File No: NTH18/00047/11  
Your Ref: SSD10353

**Re: Review of EIS for Tweed Valley Hospital – Stage 2. - Major Project SSD10353.**

I refer to your email dated 4 October 2019 requesting comment from Roads and Maritime Services in relation to the above mentioned EIS for the construction of the Tweed Valley Hospital (stage 2 of the project).

ACCESS AND INTERSECTION PLANS

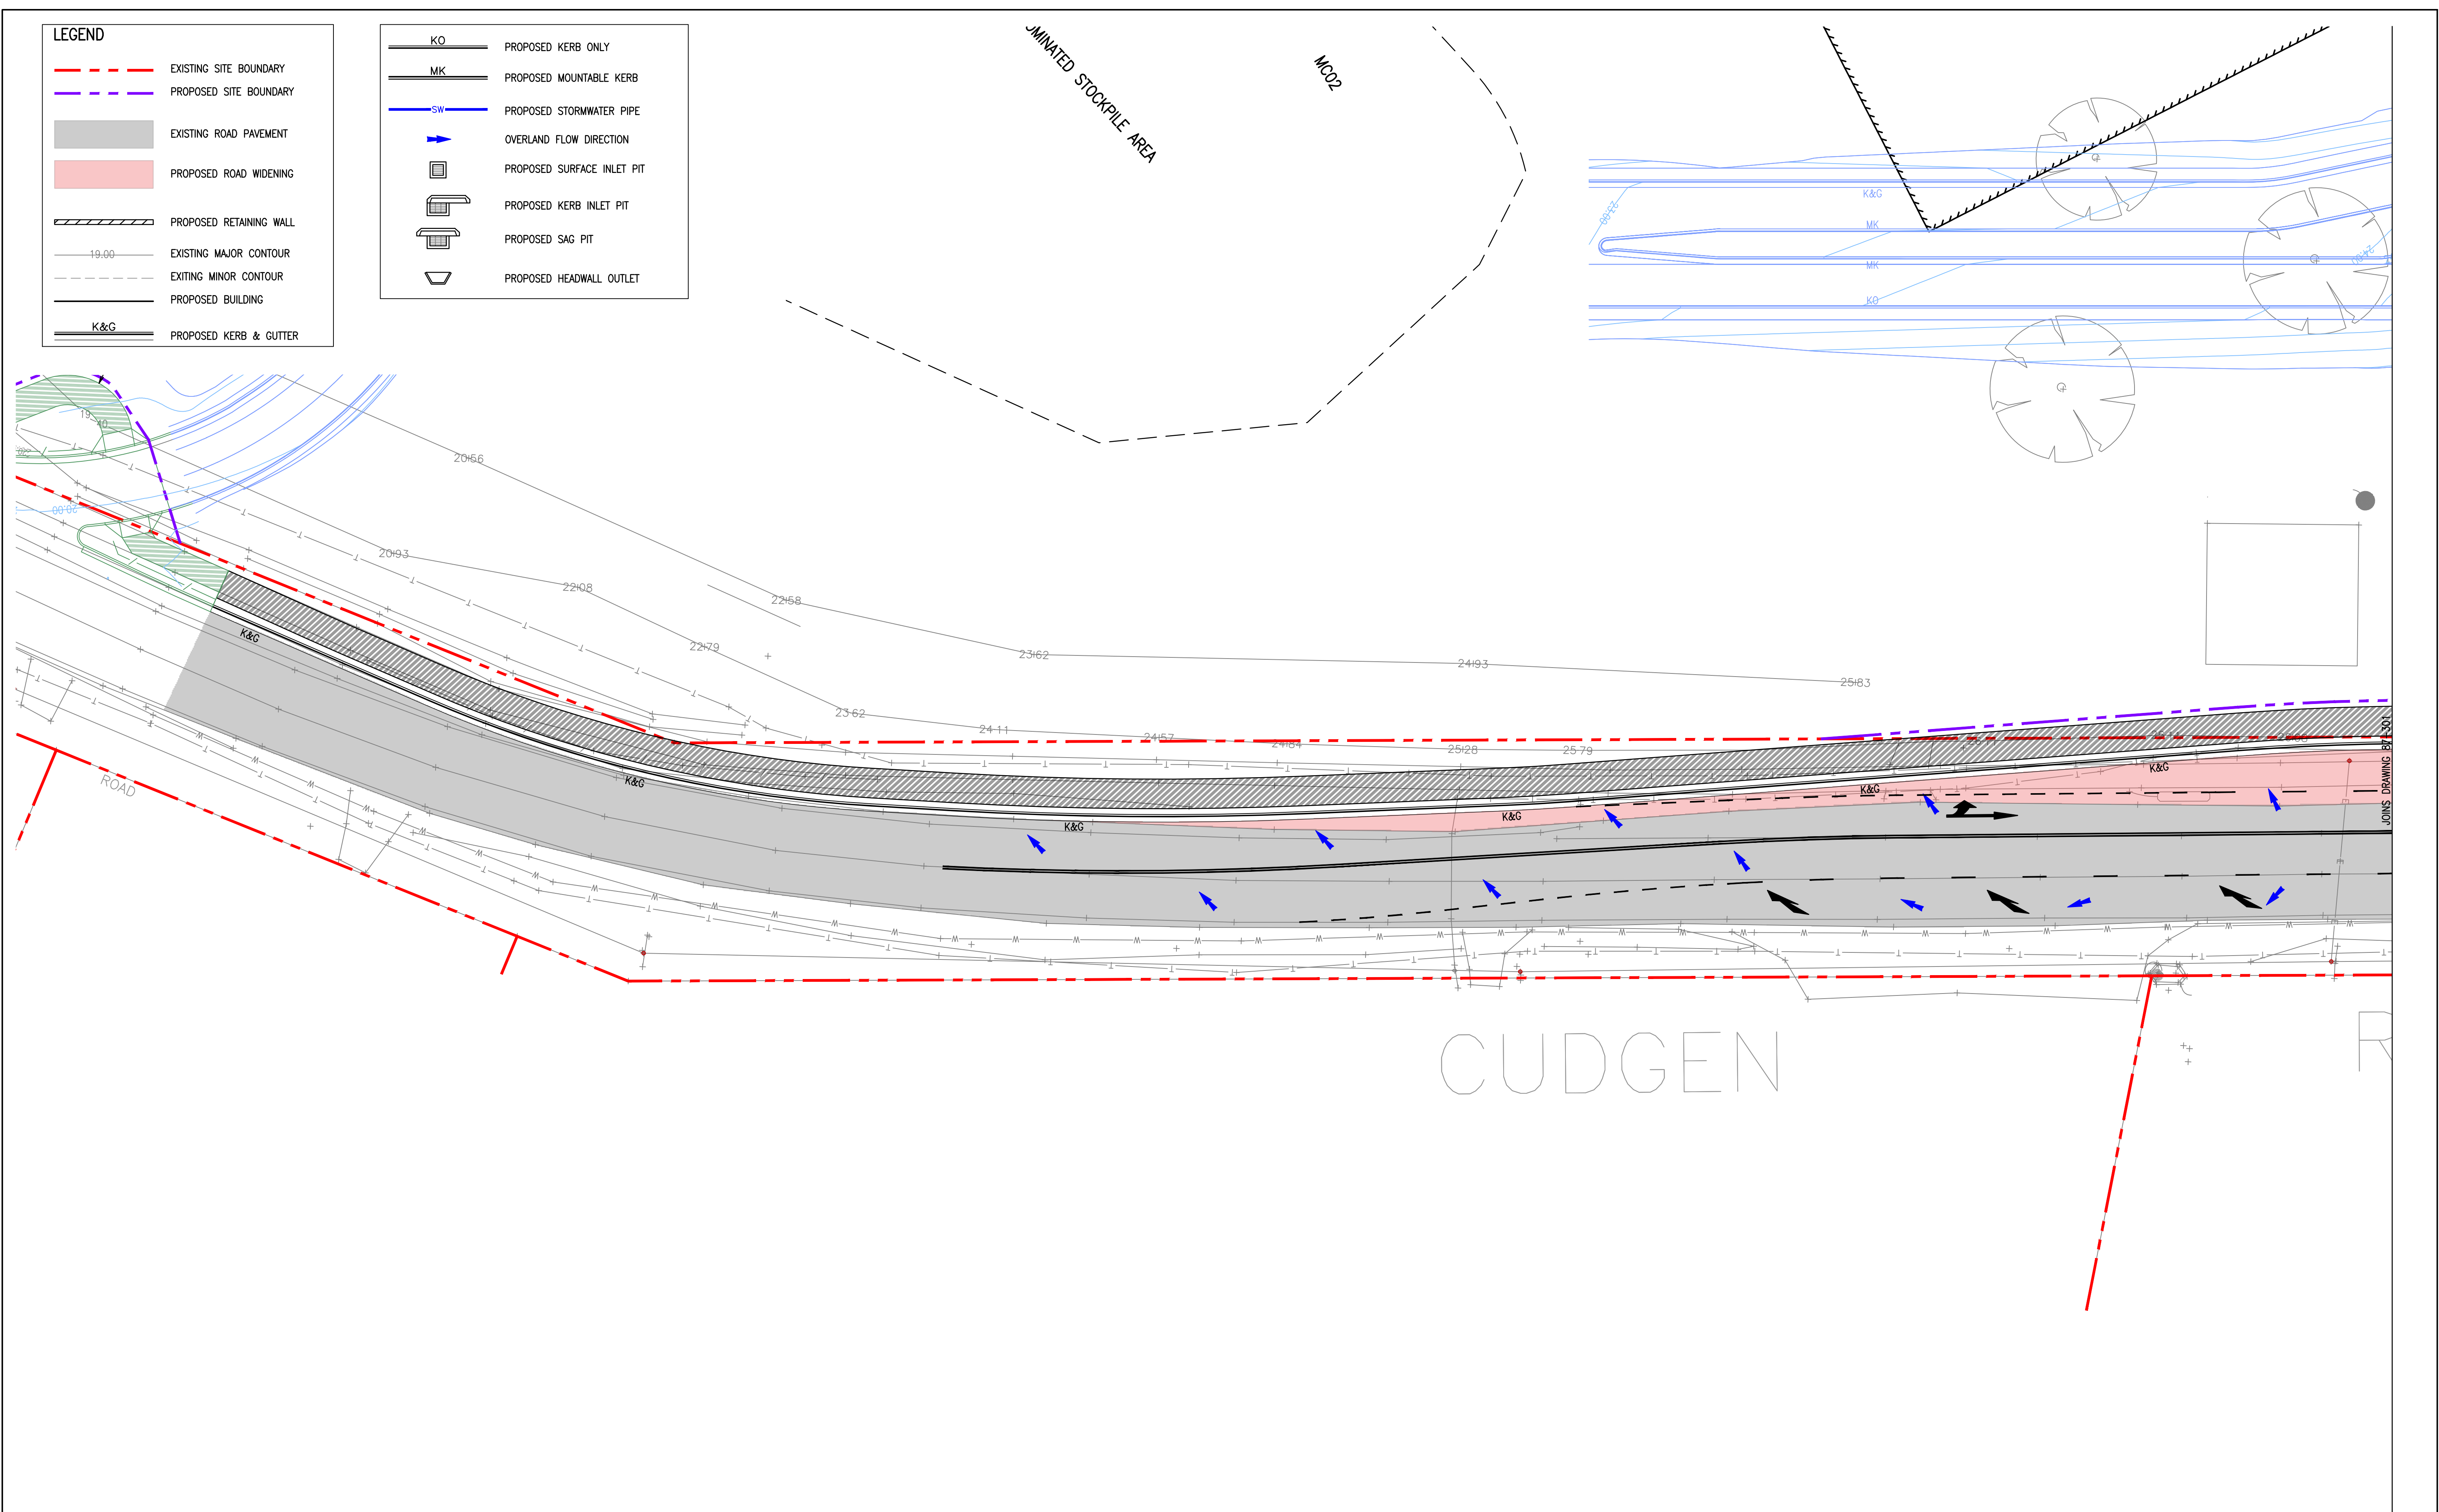
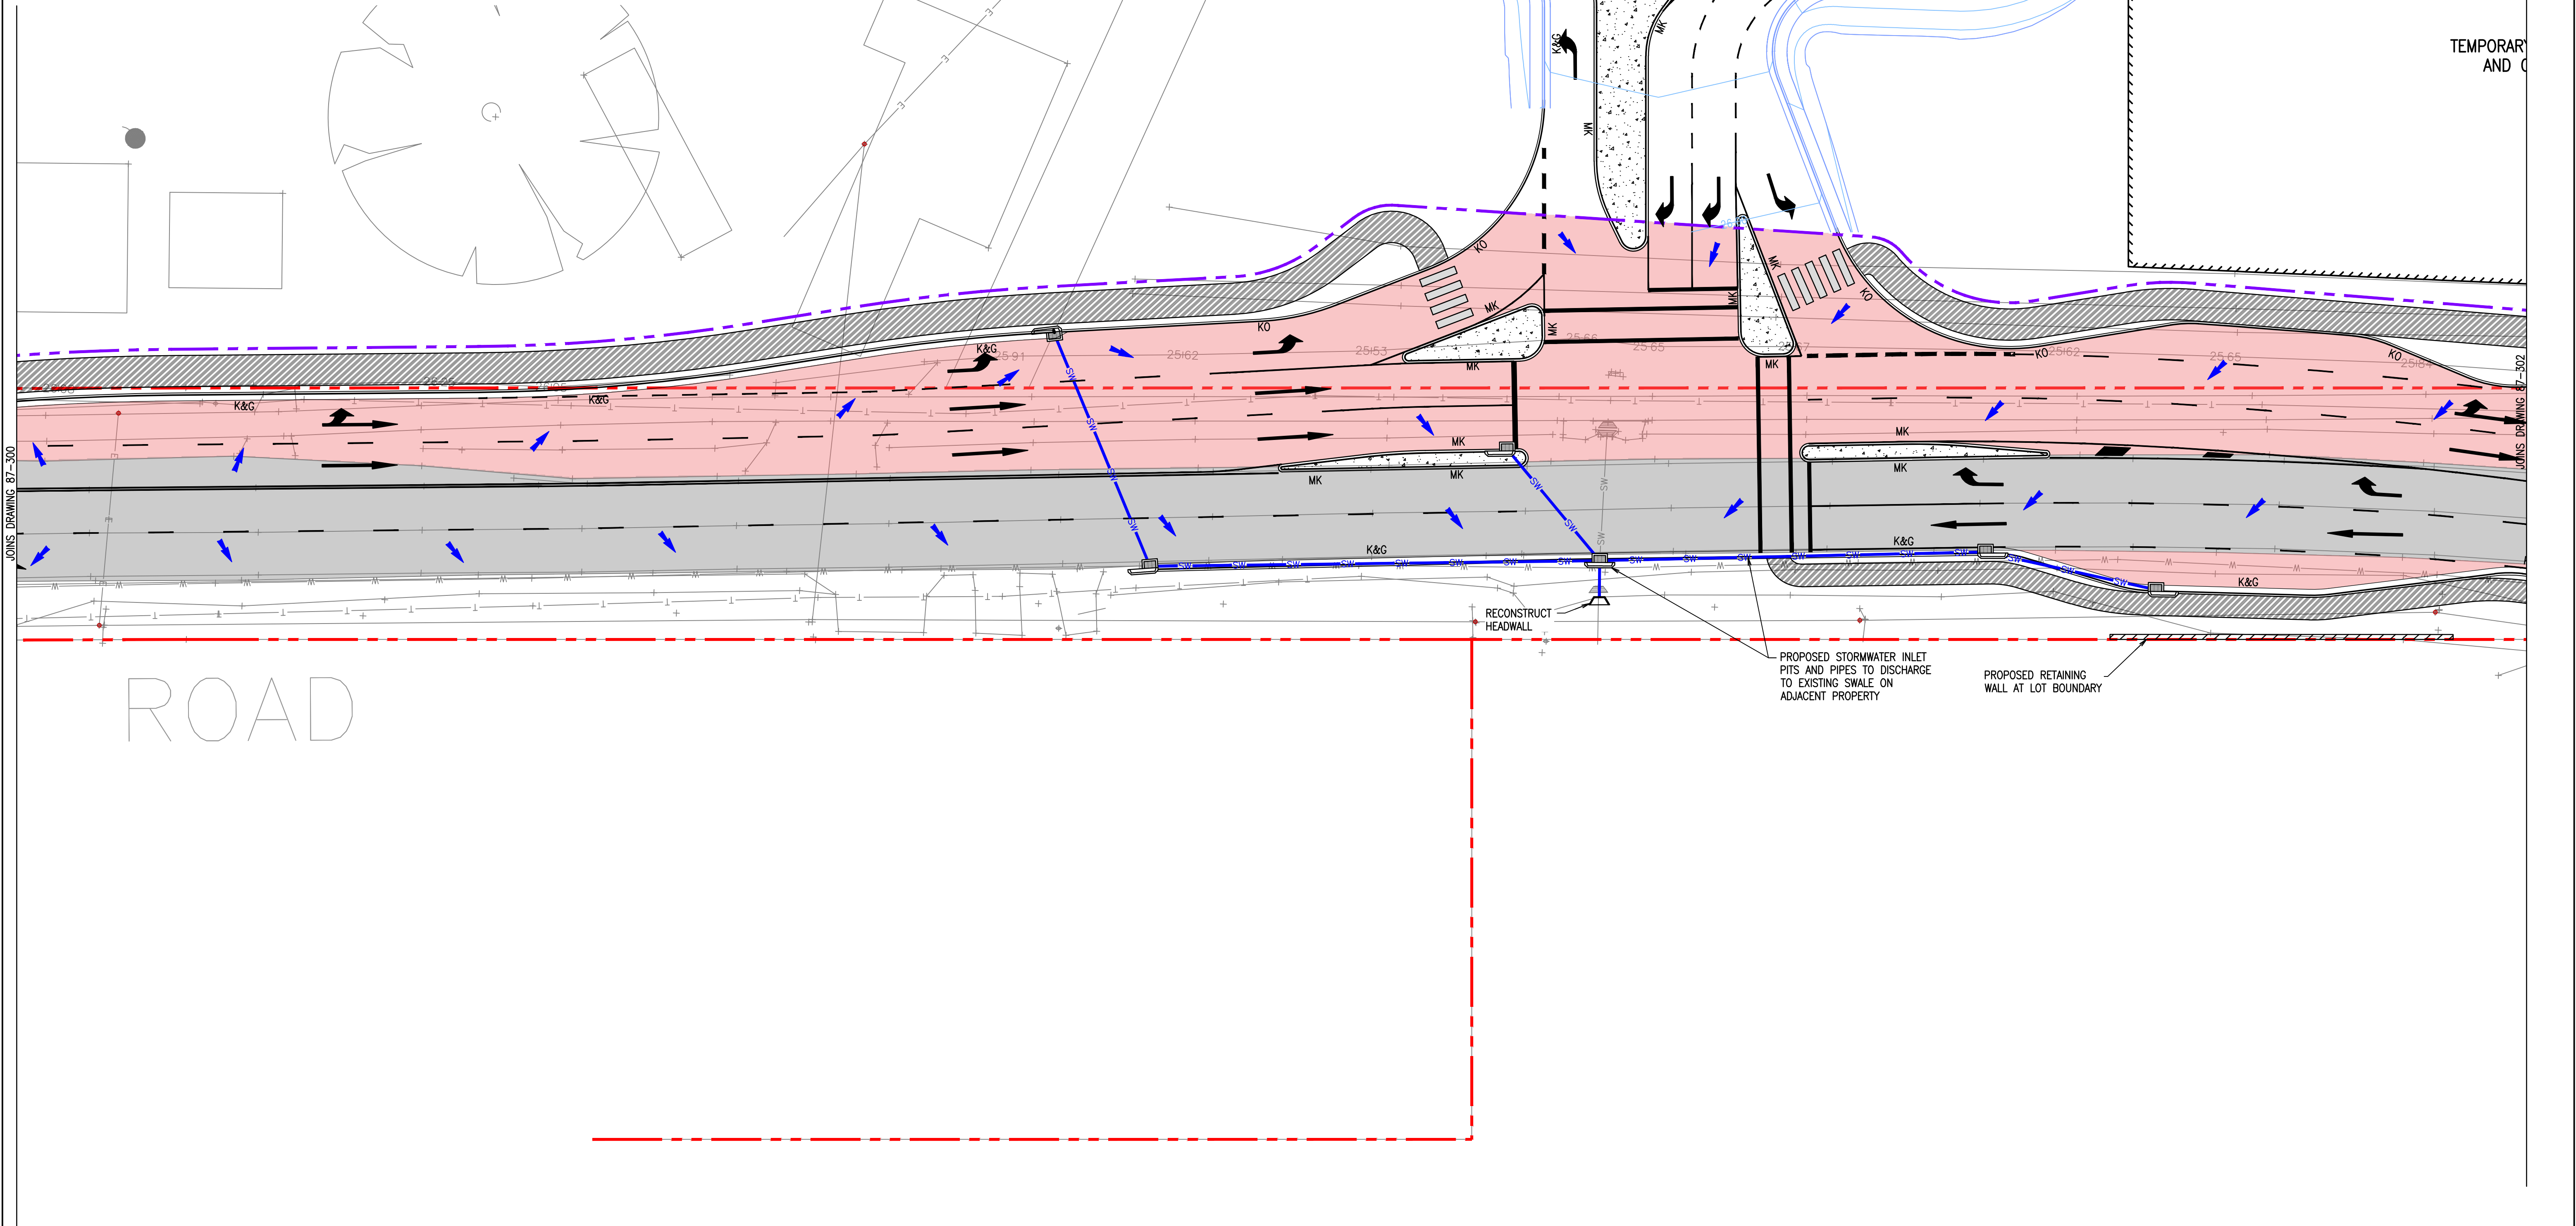
- Stage 1 consent condition B22 (c) requires plans for the upgrade for Tweed Coast Road/Cudgen Road intersection. The plans provided for stage 2 have no dimensions and should be updated to include the additional lengthening of the Tweed Coast Road north-bound right-turn bay, and left-turn deceleration lanes on Cudgen Road. No detailed plans were provided for the proposed traffic signals at the Hospital entrance.

- Left-turn lanes at the Tweed Coast Road/Cudgen Road at the access into the Hospital should be designed in accordance with Austroads standards. They should be long enough to cater for deceleration and queued traffic due to pedestrian crossings or internal design. For a 60km/h speed zoned area, this would require a minimum of 55m plus queue length.

- Modelling provided with the Stage 2 EIS has indicated that only 20m storage was required for the east-bound left-turn deceleration lane. This should be lengthened to provide 55m to cater for deceleration and queuing back from the hold line as only a single entry lane is provided for both left and right-turning entering traffic into the site. This change should also apply to the four other left-turn slip lanes (east-bound left-turn lane at Tweed Coast Road signals; and the three along the frontage of the site).

- The existing left-turn slip lane for vehicles turning from the western approach to Cudgen Road into Tweed Coast Road has limited storage. SIDRA modelling indicates that this lane needs to provide more capacity. Any queuing will have a significant impact on through and right-turn traffic. It is noted that the northern side is constrained by existing residential. It is suggested that strategic drawings be provided to show queue lengths, and that Council/State Government confirm that those lengths are acceptable and meet Austroads standards.
